+ MODIFICATION OF MAJOR PROJECT APPROVAL NO. 08_0194 (MOD 8)

KINGS FOREST STAGE 1 – CONDITIONS 8, 14 AND 23(6)

At Kings Forest, Tweed Coast Road, Kingscliff

• Prepared For: Project 28 Pty Ltd | • Prepared by: DAC Planning Pty Ltd | • November 2018 |

ROAD HIERARCHY
AND STAGING PLAN
SHEET 2

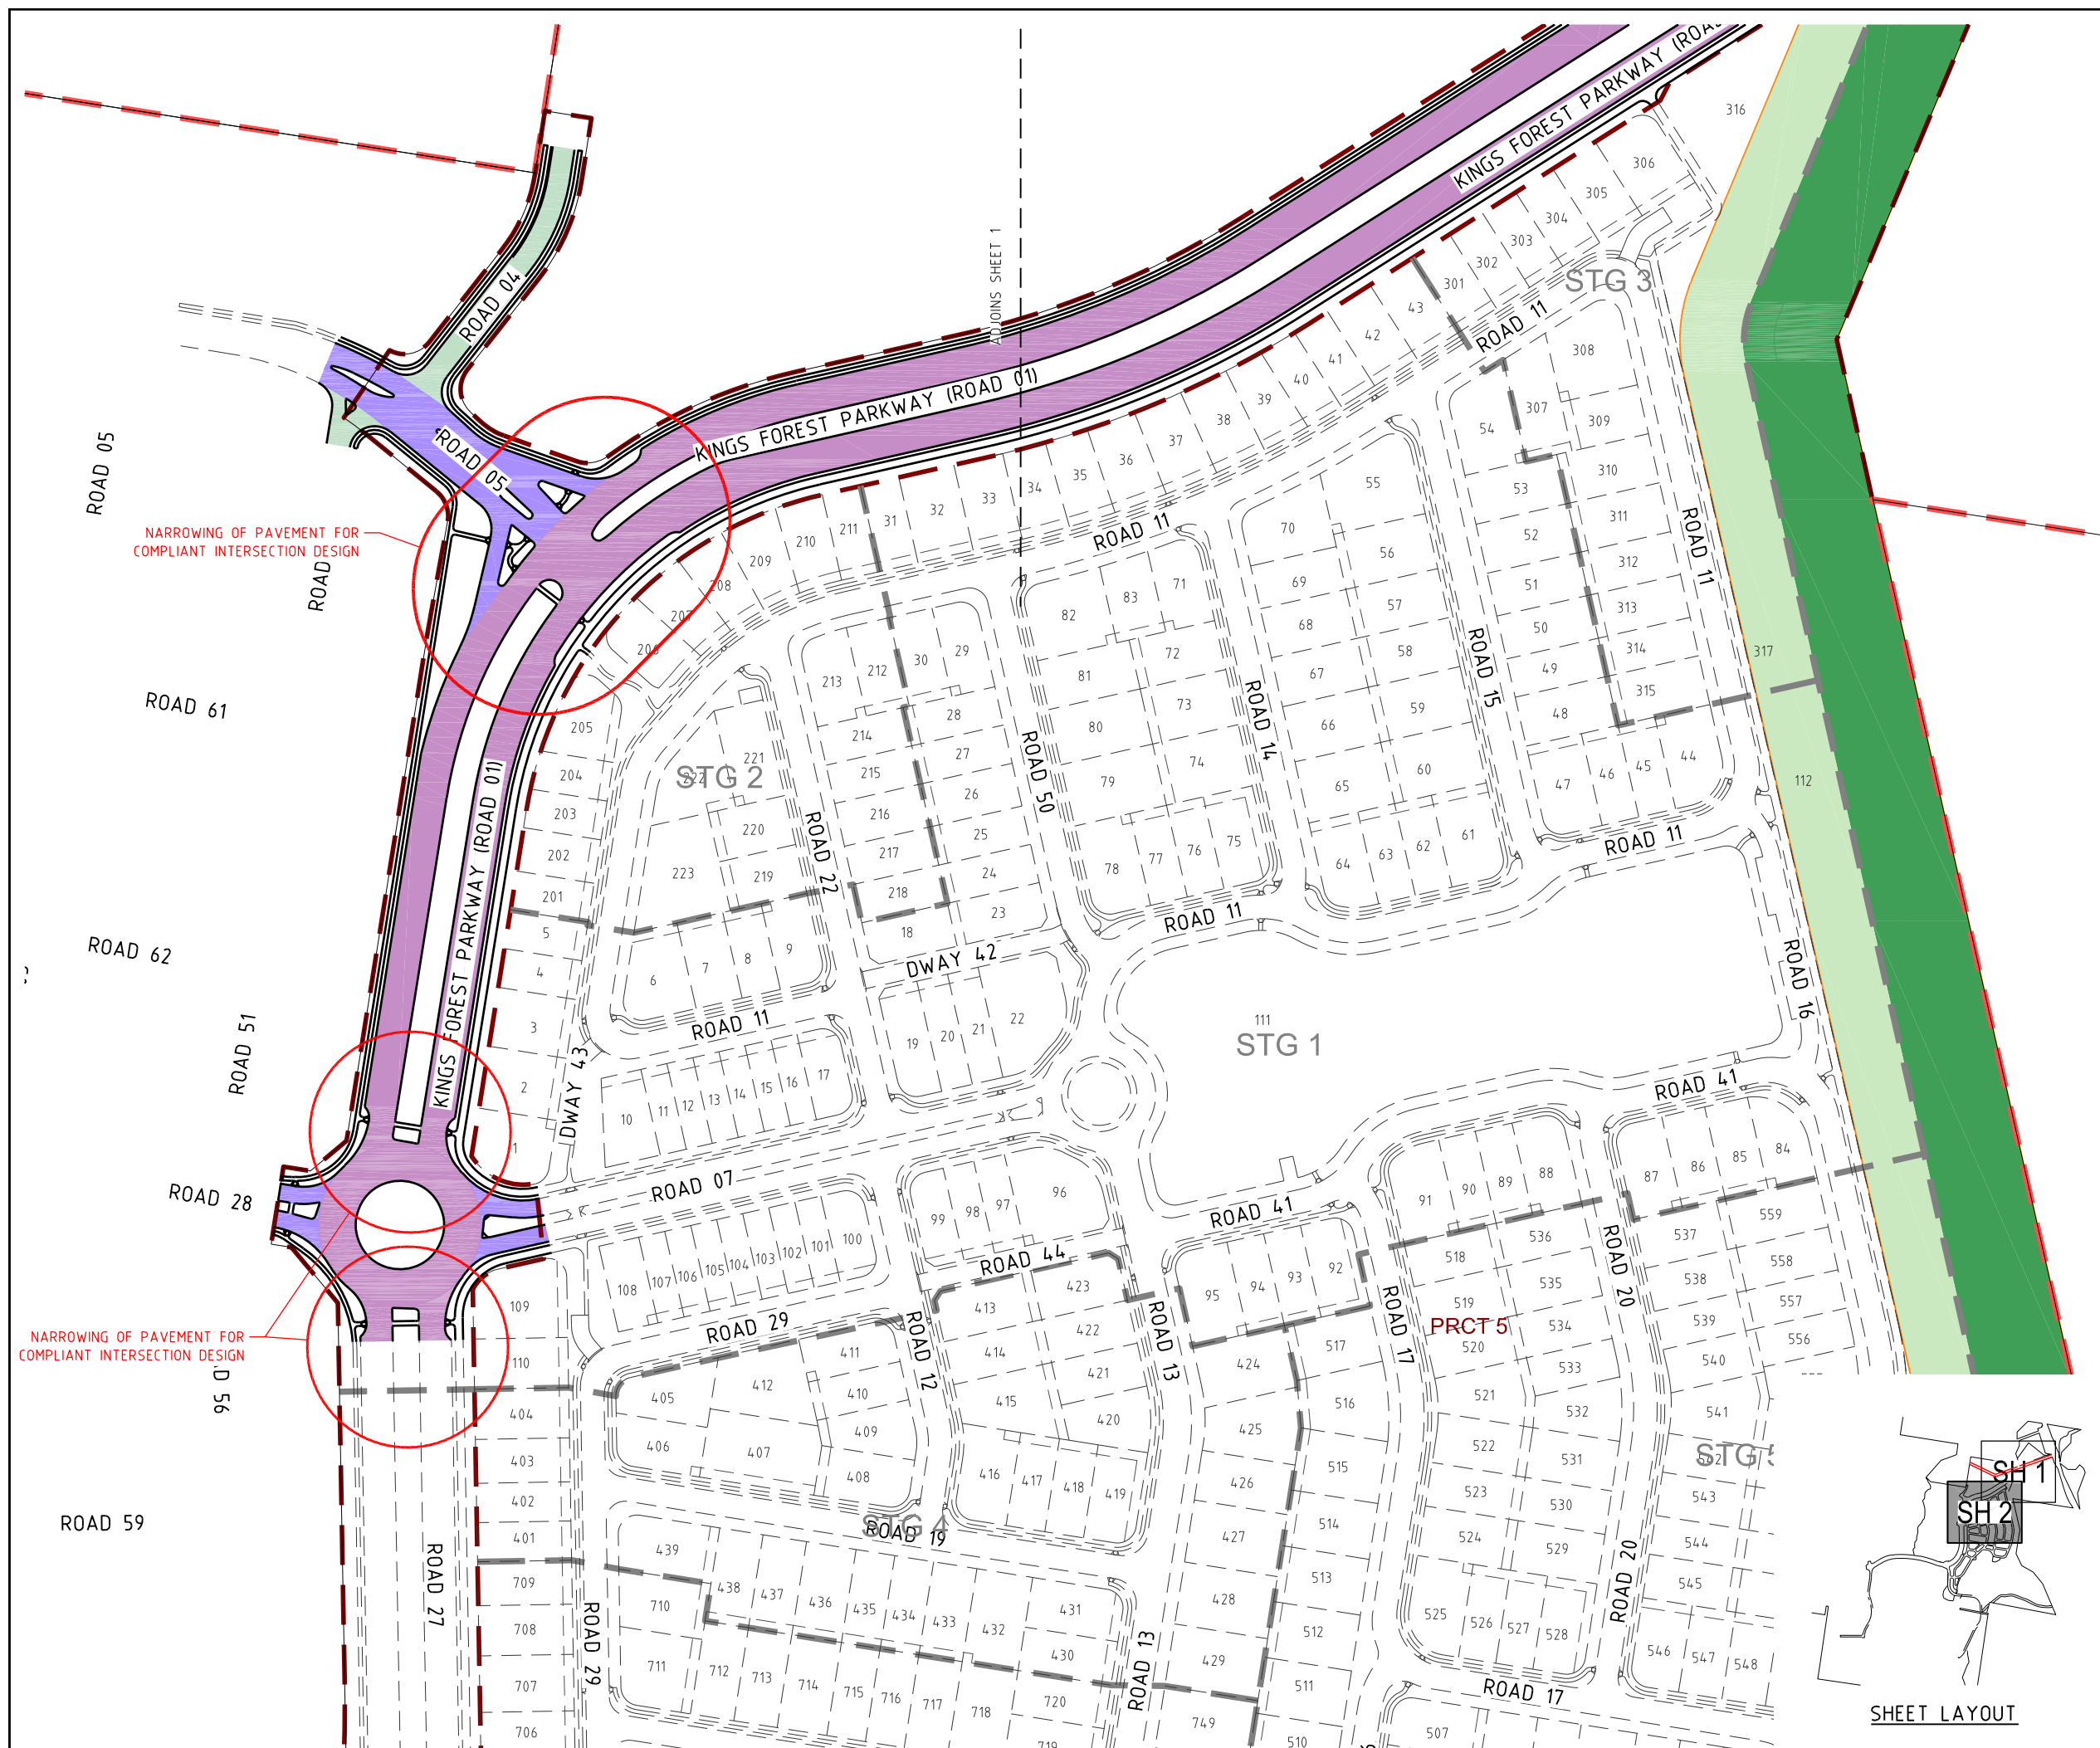
In preparing the Detailed Engineering Plans to accompany the Construction Certificate Application for Kings Forest Parkway, it has become apparent that the 9m minimum pavement width cannot be achieved. This is because of environmental constraints imposed by the environmental zone, ecological issues (narrowing to not less than 7m for the provision of Koala underpass structures), the property boundary of No. 254 Old Bogangar Road, on the north side of Kings Forest Parkway and Cultural Heritage Area 3 on the southern side of Kings Forest Parkway. In addition, narrowing of the carriageway is required at intersections to conform with Austroad Standards.

The constraints and proposed cross section are shown on the plans at **Annexure B**.

The proposed minimum carriageway width of 7m can be given effect by amending Condition 23(6) as follows:

23 (6) Kings Forest Parkway road carriageway is to be constructed to a minimum pavement width of 9m from the entry with Tweed Coast Road through to proposed Road 9, with the exception of those sections of Kings Forest Parkway, including intersections that conform with Austroads Standards, shown on Drawing No. 12301-SK-122, Amendment A, Morton Urban Solutions, 29 June 2018, and Road Hierarchy and Staging Plan, Drawing No. 12301-EMAW-005 and 006, Rev A – Mortons Urban Solutions which shall have a minimum pavement width of 7m. These details are to be provided on an application for a Construction Certificate.”
